v2_Drainage Report - Final.pdf Markup Summary

**FALCON RANCHETTES FILING NO. 1A - WATER QUALITY EXCLUSIONS**

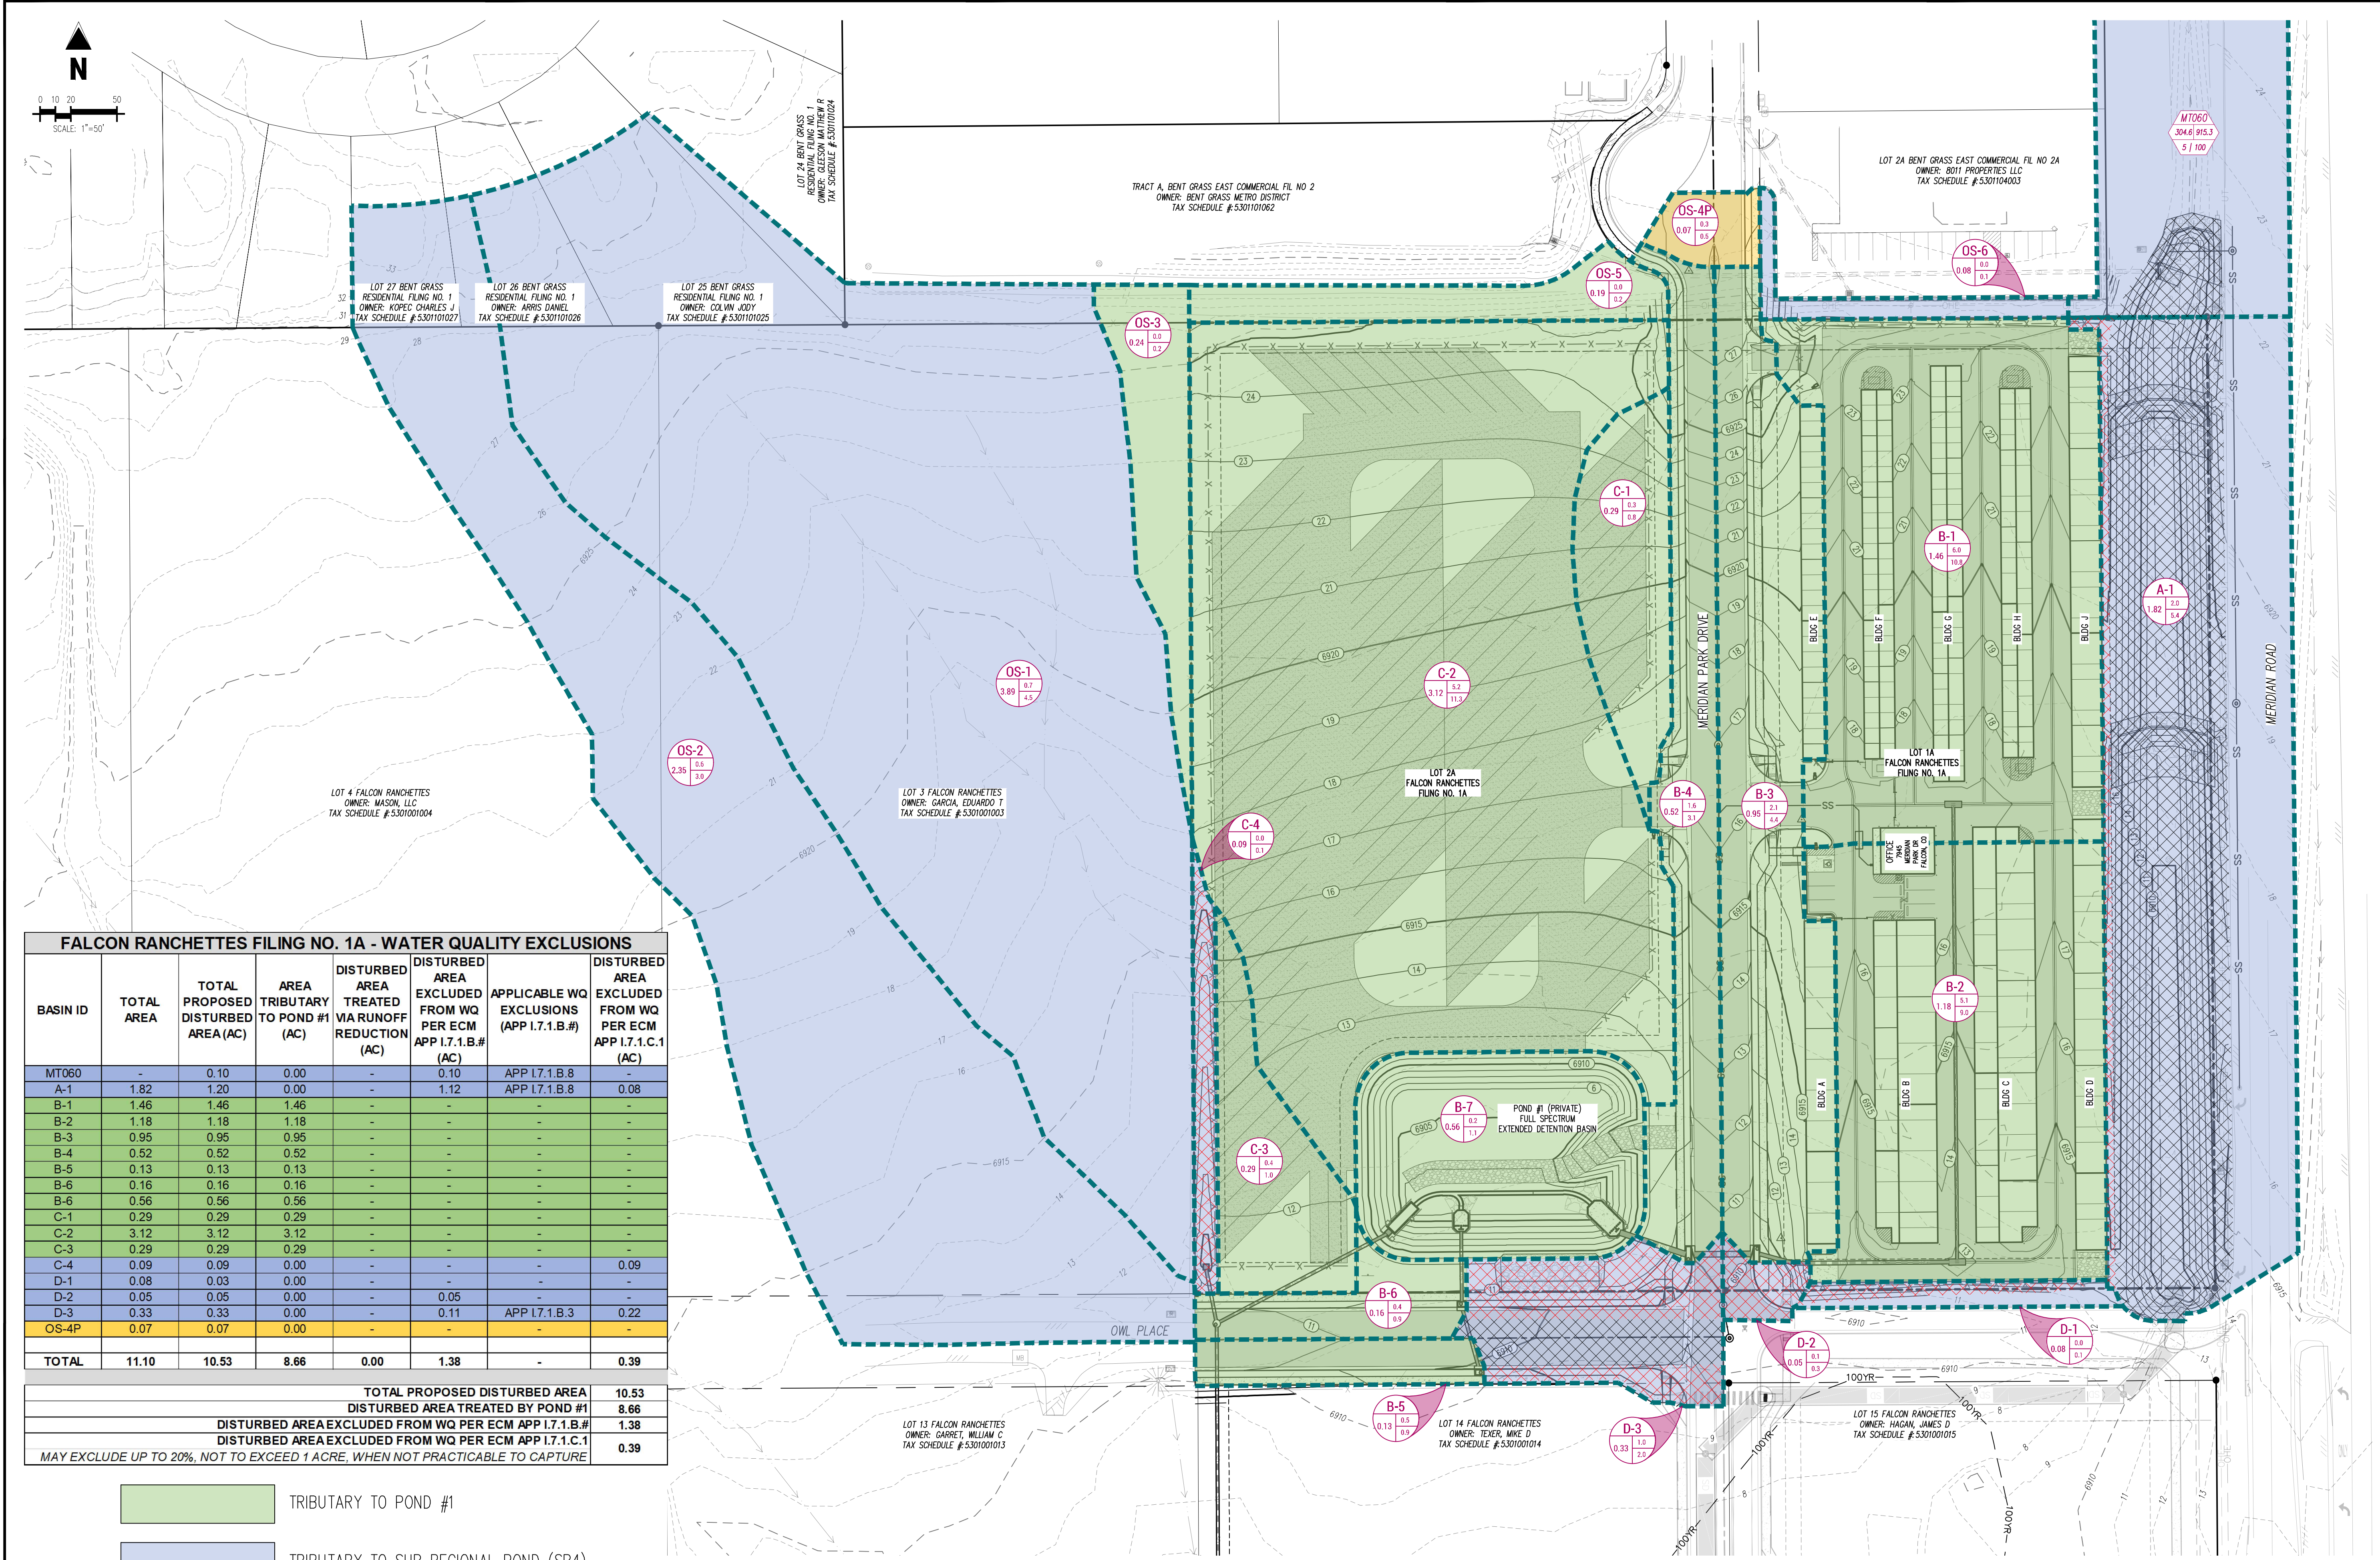
Unresolved from Submittal 1: Discuss any WQ treatment exclusions (i.e. I.7.1.C.1)
